**Consultation Response from KC,
 Lead Local Flood Authority**

**2026/90937 Gomersal St Marys C of E First & Nursery School, Shirley Avenue, Gomersal,
 Cleckheaton, BD19 4NA**

**Date Responded: 06/06/2026
 Responding Officer: Martin Stephenson
 Responding Ref: 1**

Appendix F – Drainage Layout

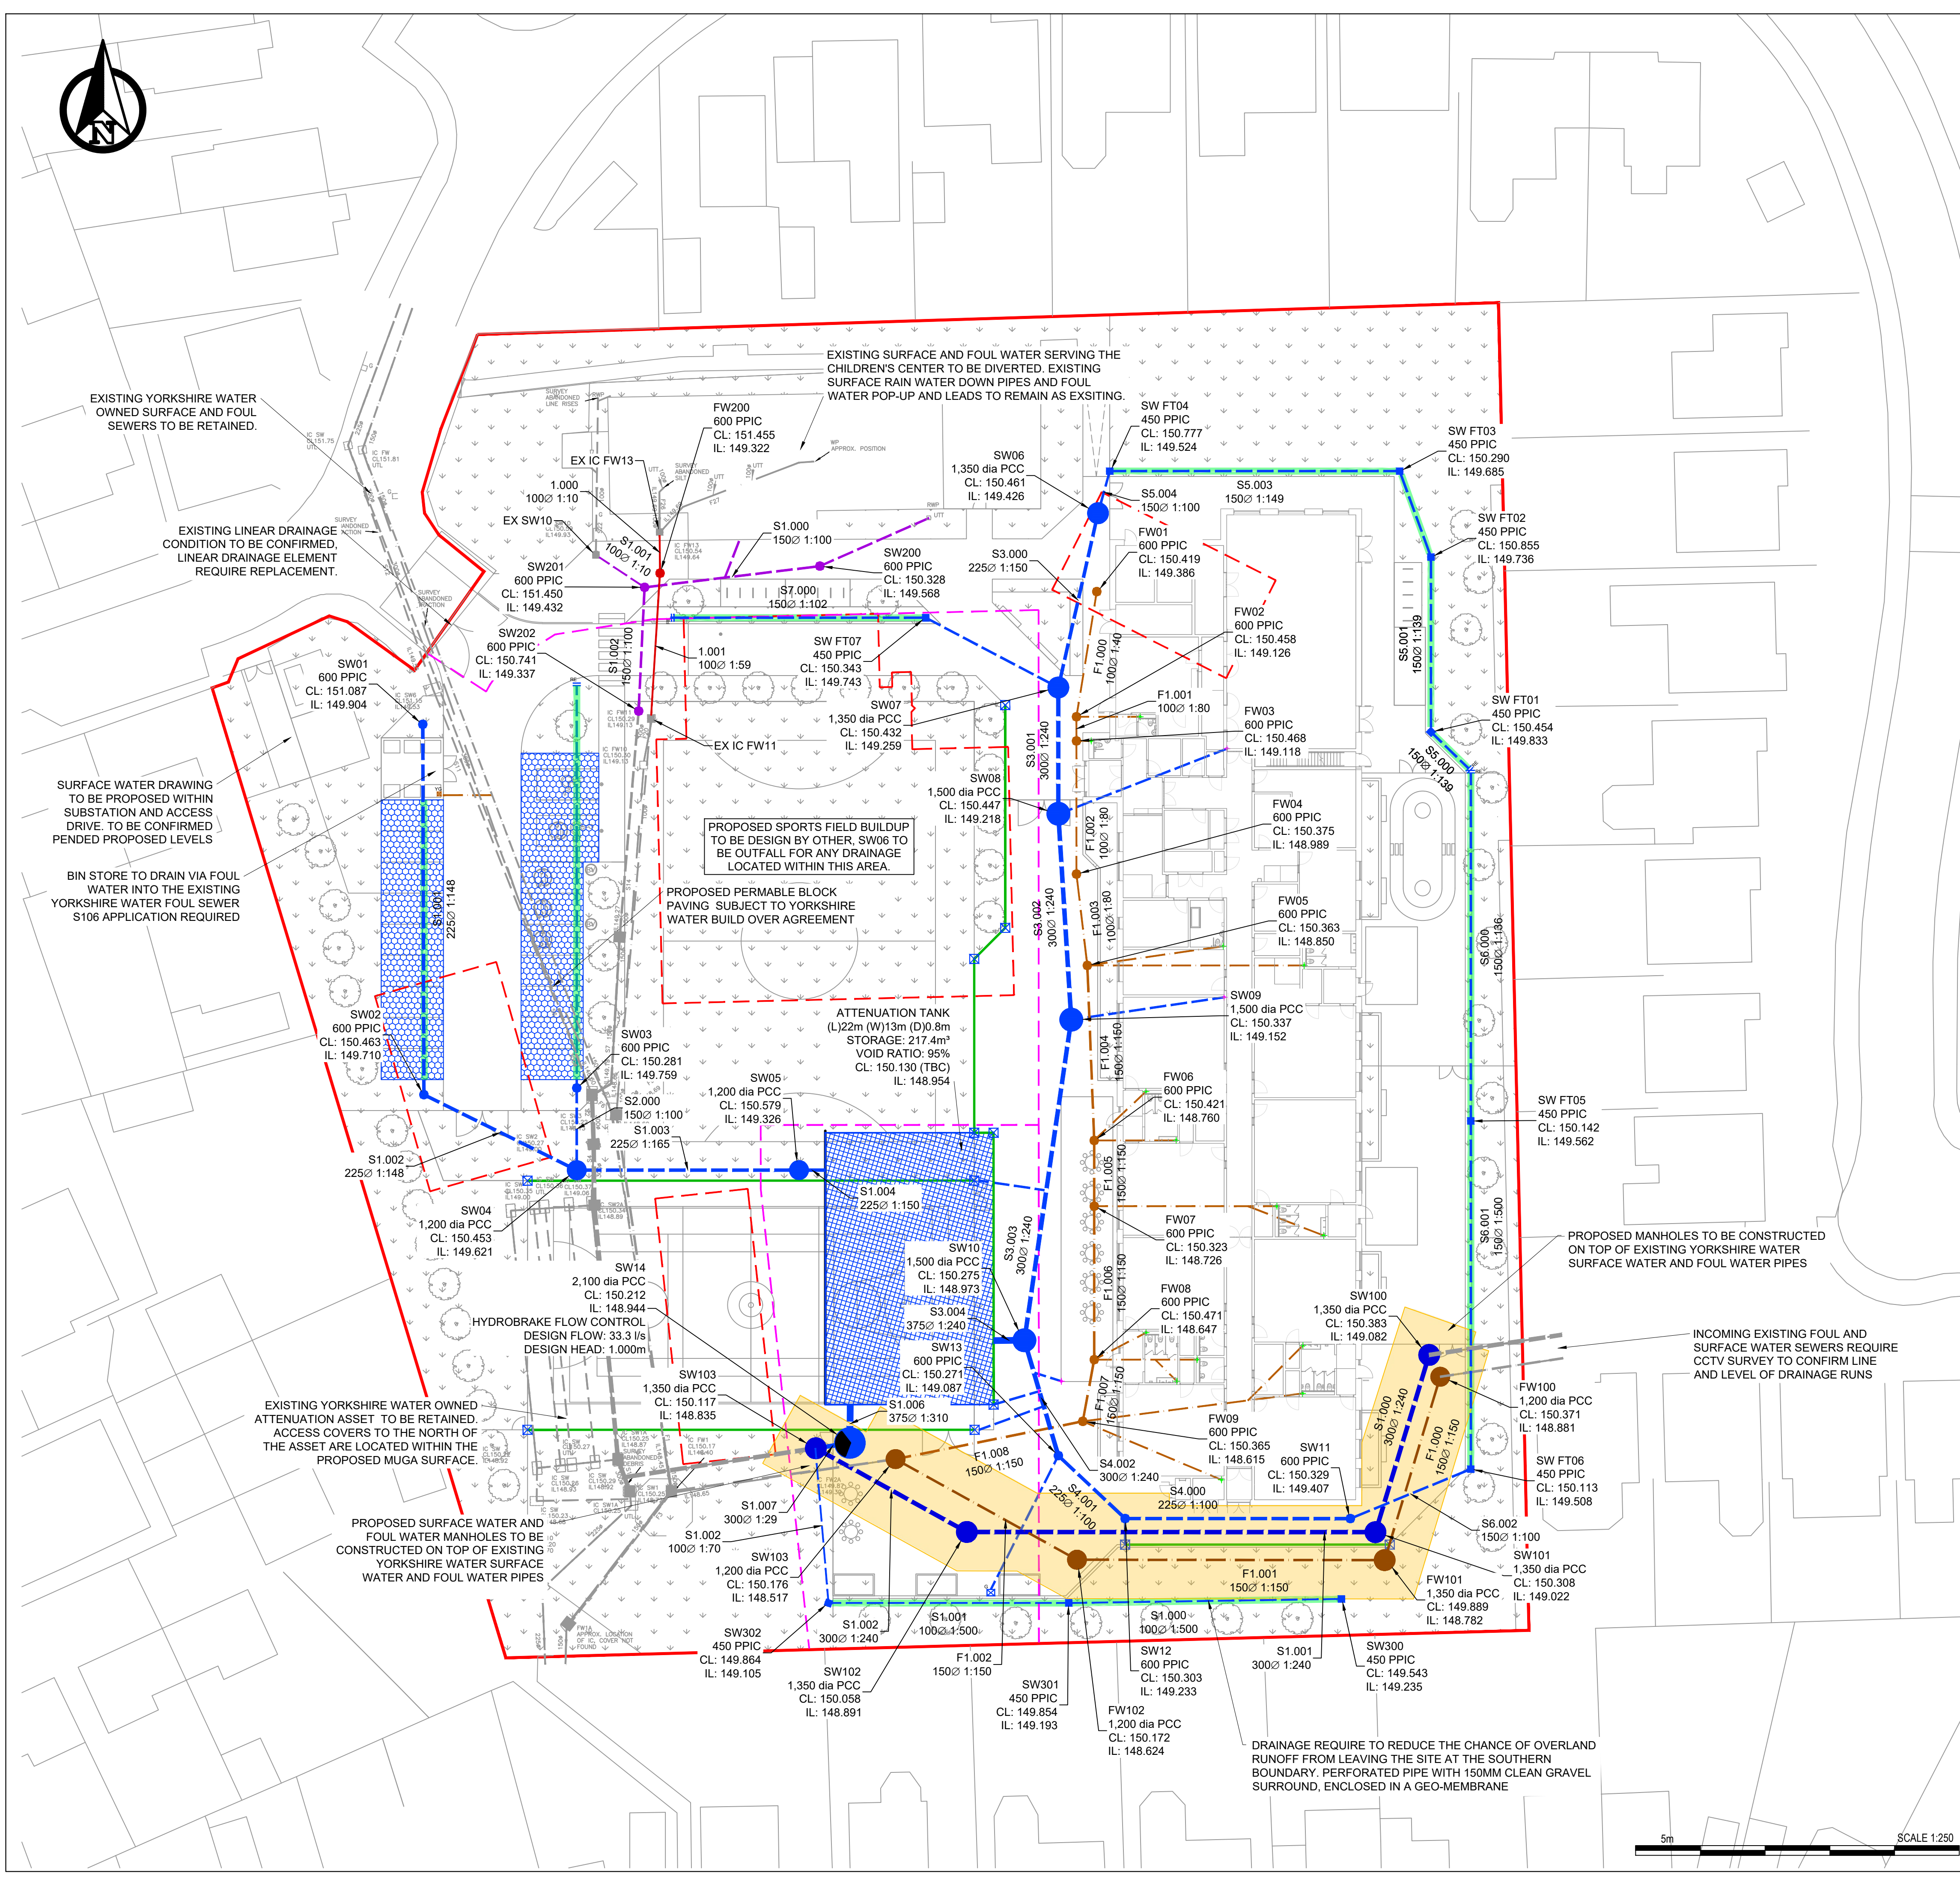
The LLFA confirms that infiltration is not feasible and therefore attenuated surface water run-off can be discharged into the 300mm diameter public surface water sewer on the southern boundary of the site (subject to Yorkshire Water approvals). Calculations are required to show that the allowable surface water discharge rate into the sewer represents a 30% betterment of the existing flows. Hydraulic calculations also will be required to confirm that the proposed attenuation storage volume is sufficient to contain a 1 in100 year (plus Climate Change allowance) rainfall event without flooding of existing/proposed buildings or off-site flooding. Details of how the attenuation tank will be accessed for inspection and maintenance will need to be provided together with a Maintenance Schedule for the tank, flow control device, gullies, etc.

Development shall not commence until a detailed design scheme detailing foul, surface water and land drainage, including the agreed surface water discharge rate with the LLFA indirectly or directly to watercourse, attenuation for the critical 1 in 100 (plus an allowance for climate change) rainfall event, attenuation construction details /design, plans and longitudinal sections, hydraulic calculations and phasing of drainage provision has been submitted to and approved in writing by the Local Planning Authority. The scheme shall include a risk assessment and method statement, in accordance with CDM Regulations 2015, for access to and into the attenuation structure, and the scheme shall include a maintenance and management plan for surface water infrastructure. No part of the development shall be occupied until such approved drainage scheme has been provided on the site to serve the development or each agreed phasing of the development and retained thereafter.
